Application: SSI 7485

I write regarding the proposed modification to M4-M5 Link, Mod 2 The Crescent overpass and changes to pedestrian infrastructure in North Annandale, Rozelle and Rozelle Bay Foreshore area.

Figure 4-1 Overview of the proposed modification

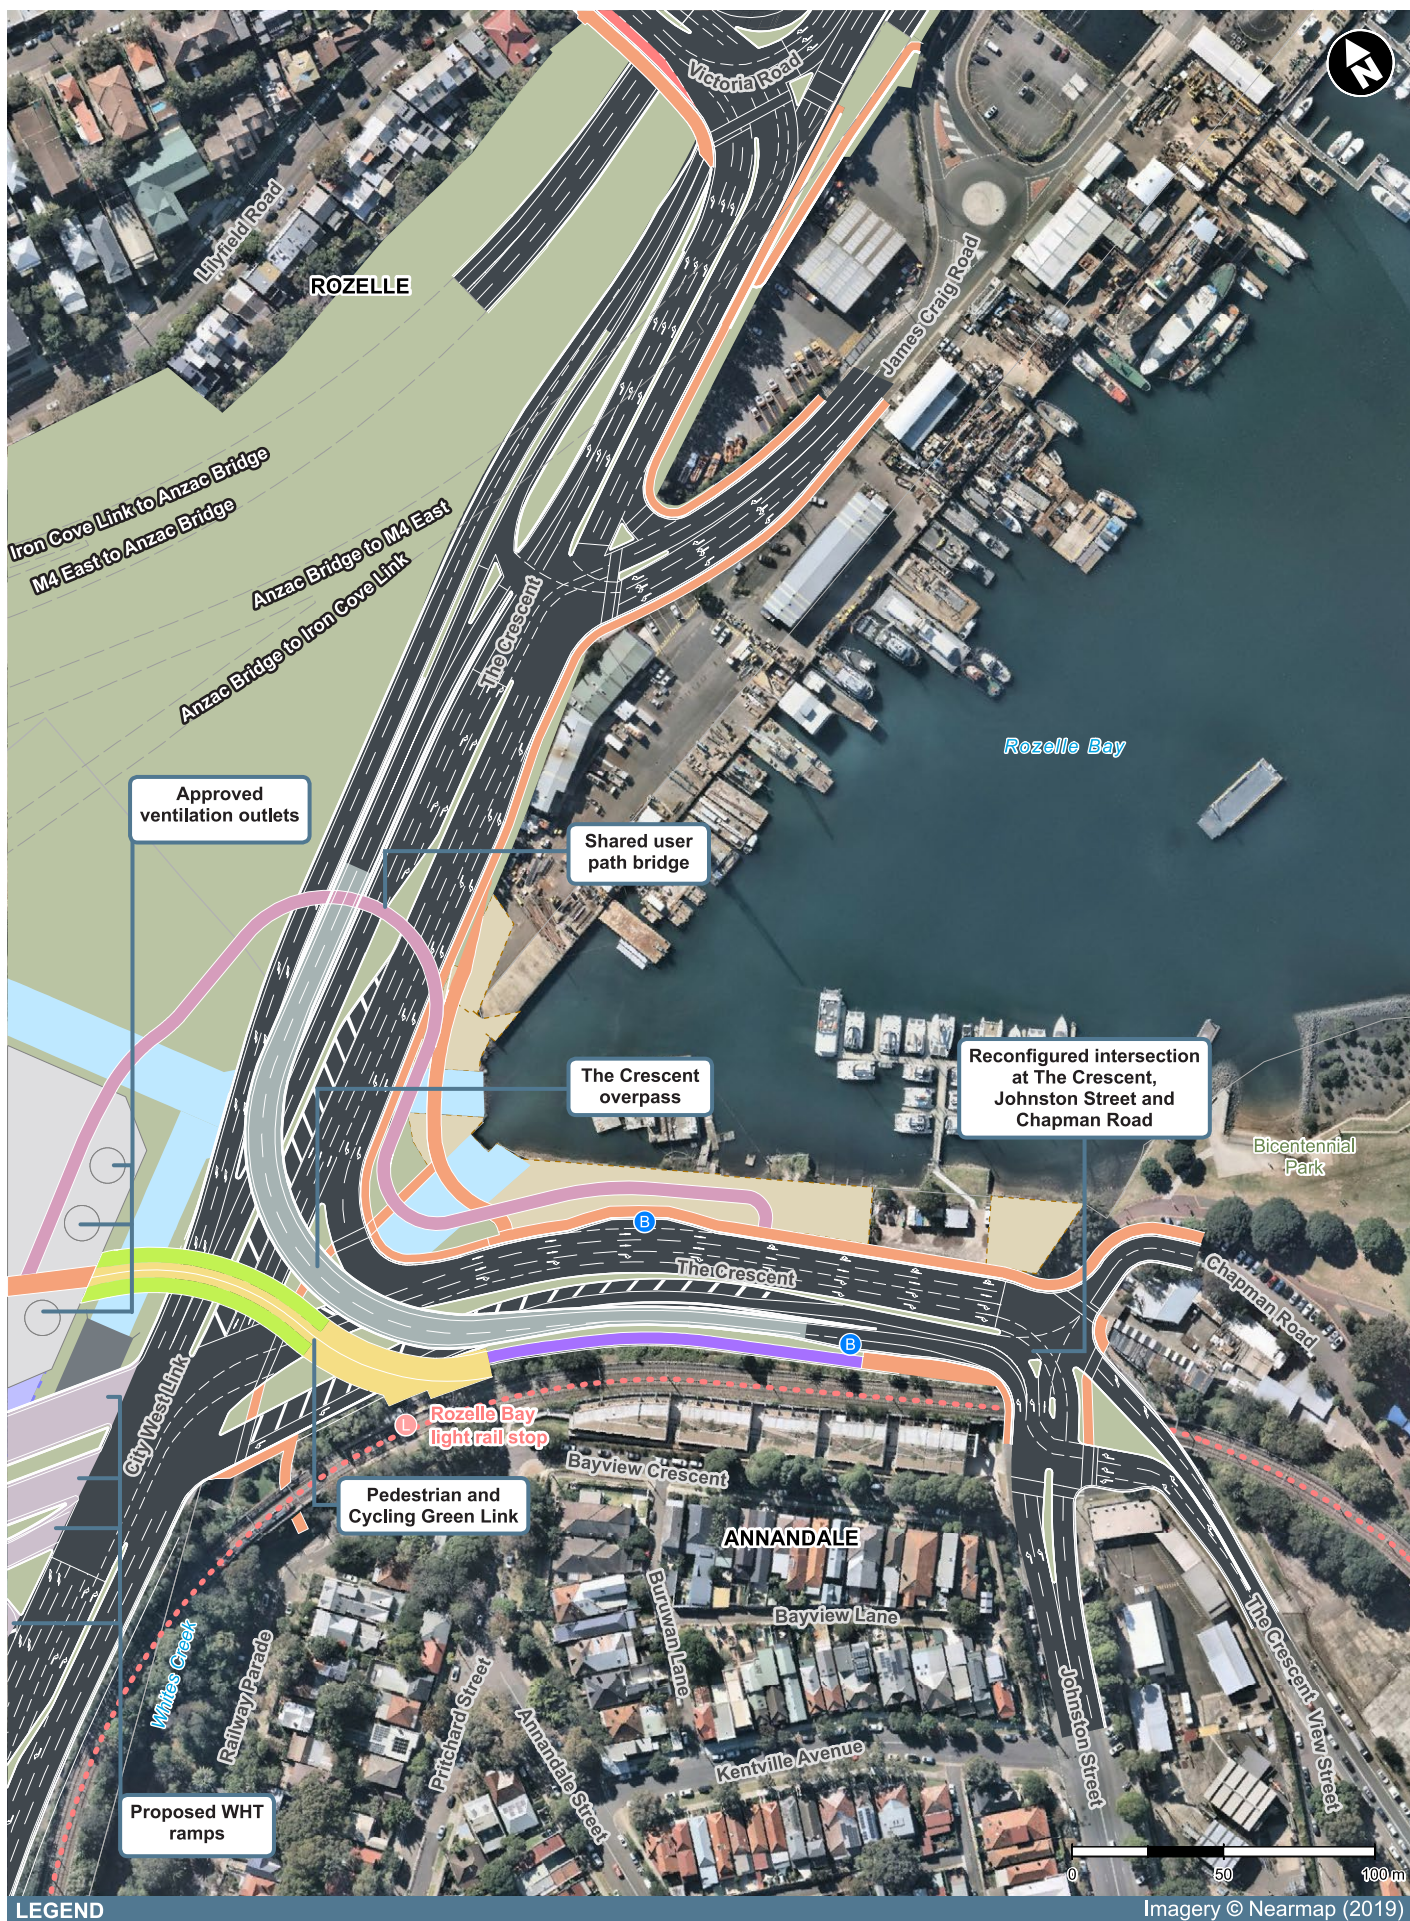
- The significantly reduced safety and increased risk for pedestrians and cyclists with removed access over The Crescent to Bicentennial Park and the increased traffic along Johnson Street.
- Being required to cross five sets of pedestrian lights at The Crescent as my option to reach the foreshore from Annandale or from Rozelle Bay light rail stop.
- Removal of direct active links to the foreshore, cutting the community off from the area and the proposed revitalisation of the entire Bays Precinct, including linking the Light Rail and Bus stops to a Ferry wharf and Metro station.
- Urban and landscape design that is being built before a finalised Masterplan for the area.
- Traffic changes that limit movements around the suburb and create further congestion in the local streets of Annandale, Forest Lodge, Glebe, Lilyfield and Rozelle with no planning to deal with these.

Figure 4-2 Pedestrian and cyclist bridge infrastructure options

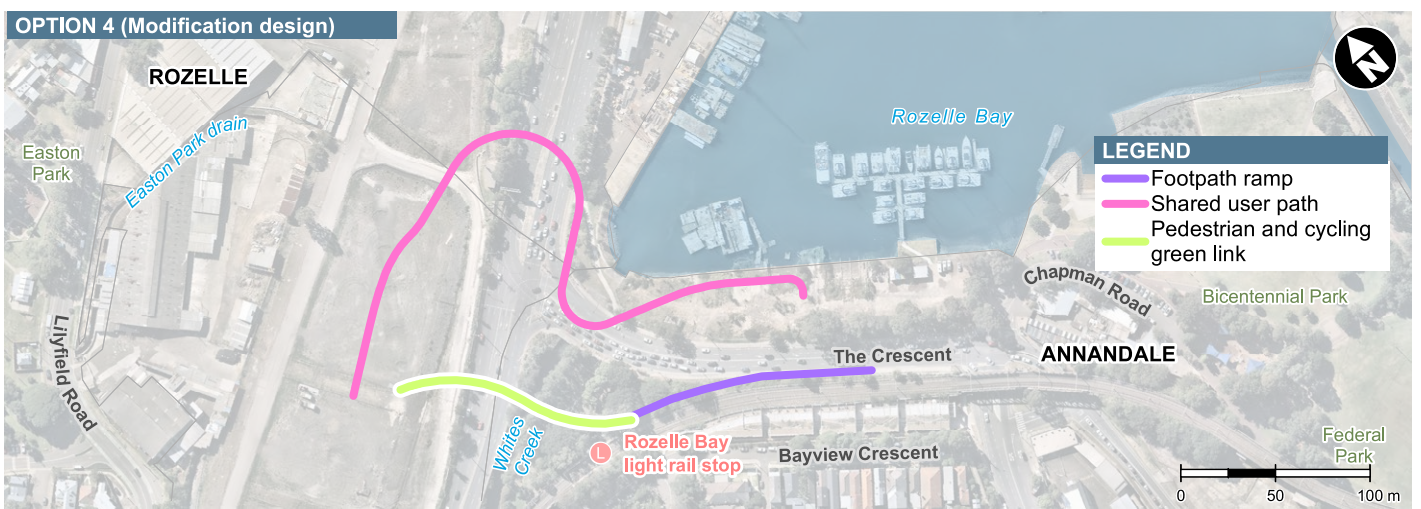
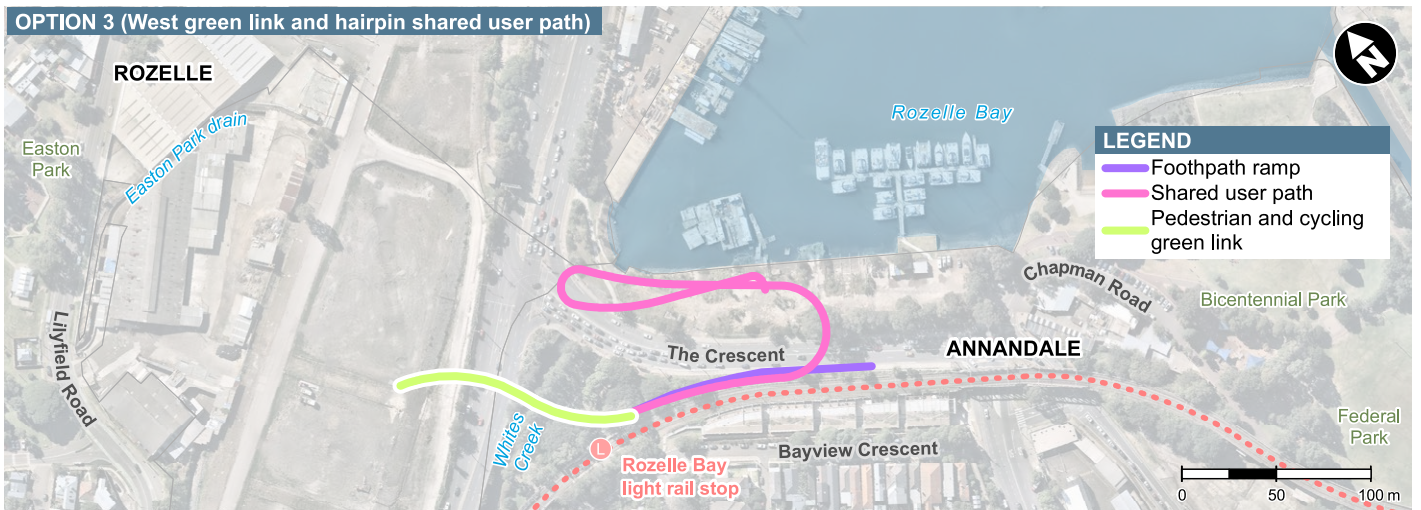
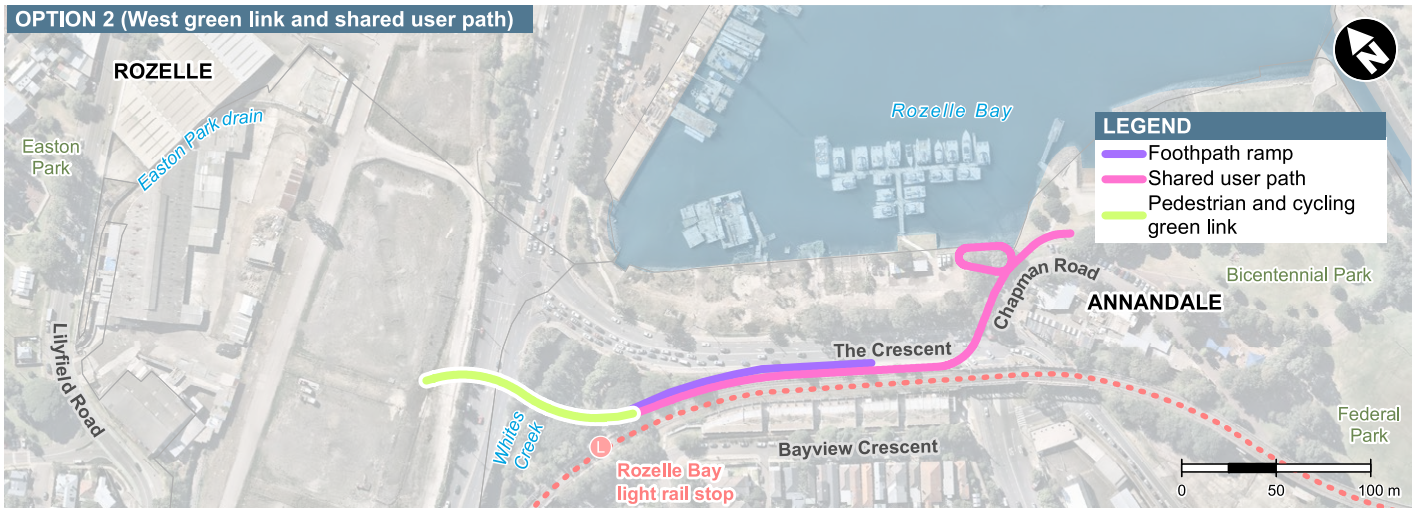
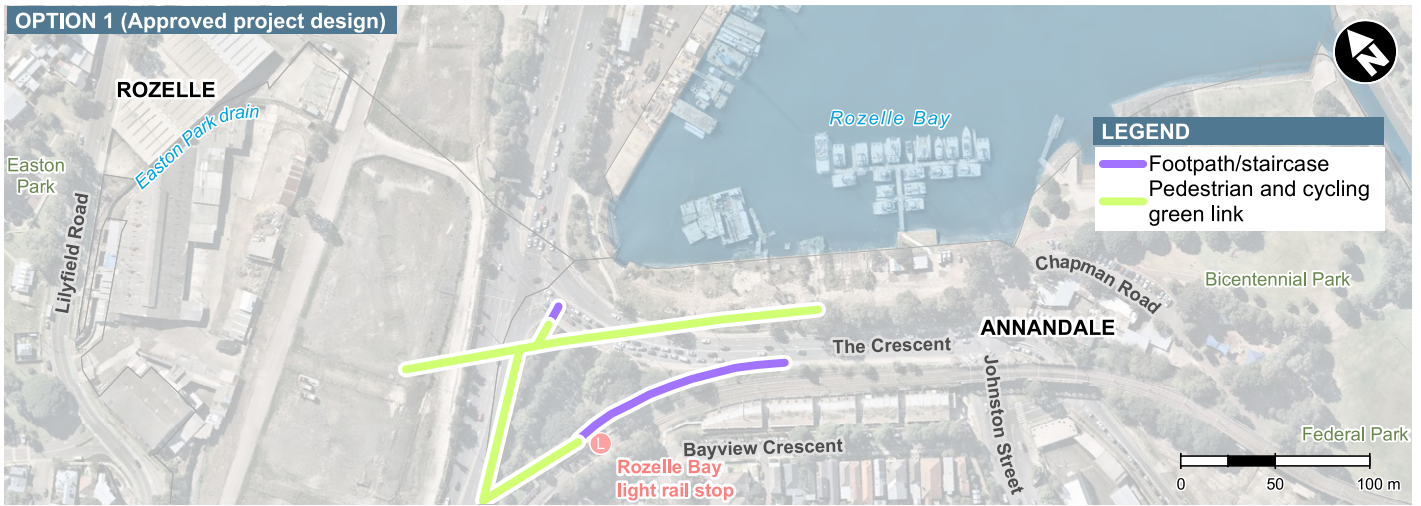
I request RMS work with the community to explore alternate design options to the proposed new car overpass design and the changed pedestrian and cyclist links. I am seeking the reinstatement of the safe, direct access from the approved EIS GreenLink to create a continuous green open space connection from the Rozelle Rail yards and Annandale to the foreshore. The GreenLink was more than just a walk way - it put people central to the design, maximising safety, and providing much needed accessible open space for the community now and into the future Bays Precinct design.

- Reinstate the GreenLink connecting communities and green open space from Rozelle to Bicentennial Park
- Relocate and design pedestrian and cyclist connections that are continuous, safe and direct.
- Design the modification infrastructure and active links in response to the character of the suburbs, the location of the foreshore and it's potential future development.
- Provide pedestrian and cyclist paths that maximise people safety and do not force them onto busier streets, unsafe concrete plazas and caged walkways.
- Integrate active and direct connections to all active transport – including the future Metro West and Foreshore Ferry Wharf
